Appeal Decision

Appeal Ref: APP/R4408/D/21/3288770

388 Burton Road, Monk Bretton, Barnsley S71 2QE

- The appeal is made under section 78 of the Town and Country Planning Act 1990 against a refusal to grant planning permission.
 - The appeal is made by Ms Aurora Montgomery against the decision of Barnsley Metropolitan Borough Council.
 - The application Ref 2021/1196, dated 1 September 2021, was refused by notice dated 23 November 2021.
 - The development proposed is a single storey rear disabled bedroom and shower.
-

PROPOSED PLAN & ELEVATIONS

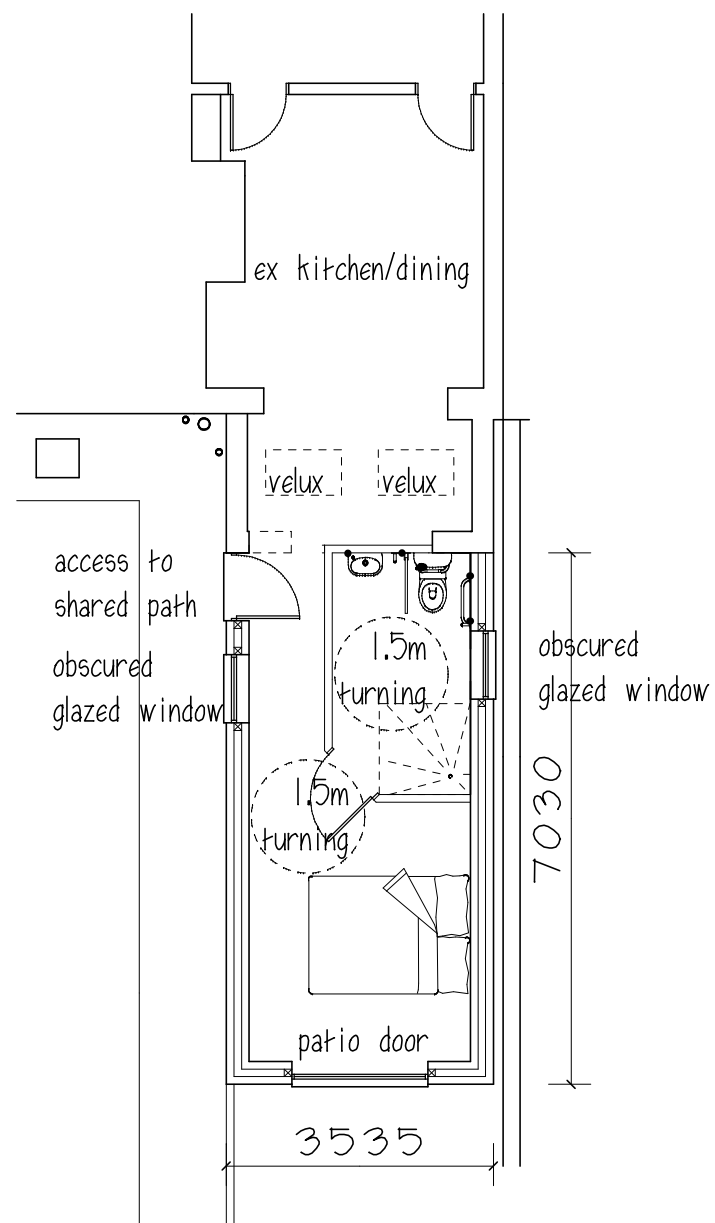
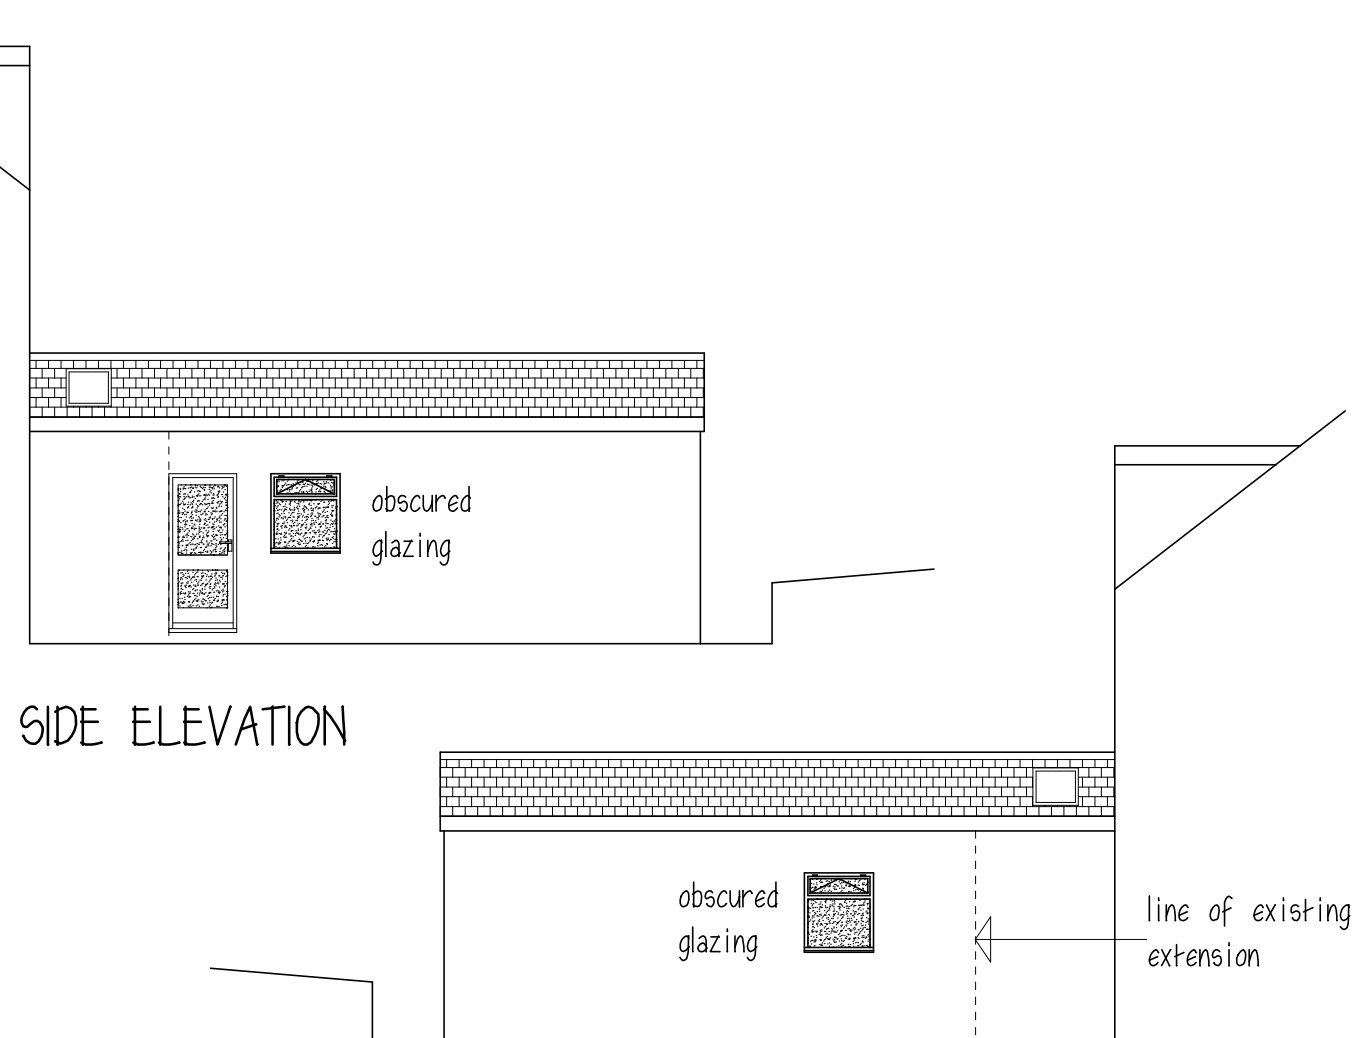
4. The proposal comprises a single storey brick finished rear extension with tiled pitched roof. It would extend some 7.03m from the rear of the single-storey extension. It would have a door and window to the side elevation facing No 390 and a window to the elevation facing No 380. All glazing would be obscured glass.

6. No 390 has a rear patio area with stepped and planted garden. Its outlook is onto the garden and the appeal site's high close boarded and painted timber fence boundary. This fence follows, on a concrete/masonry plinth, the ground profile and rises to the lane. It significantly screens the appeal property. The proposal would remove the fence and be built up to the boundary. This would

result in the outlook from No 390 being on to a large expanse of brick wall. This would exceed the SPD recommended extension length and be within the SYRDG 45 degree rule. Even with the garden view, the proposal would be much more overbearing, and dominant compared to the fence and would significantly harm the occupiers of No 390's outlook.

7. The outlook to the rear of No 380 is onto a stepped, grassed and planted garden. There is a high brick wall to the appeal property's boundary. The wall is partly covered in vegetation and has a small timber trellis to its top. This wall rises in steps and follows the appeal property's garden profile. Whilst the proposal would exceed the SPD's recommended extension length and be within the SYRDG 45 degree rule, the existing wall would screen the house at No 380 from the proposal. Therefore, the proposal would have negligible effect on the outlook of the occupiers of No 380.
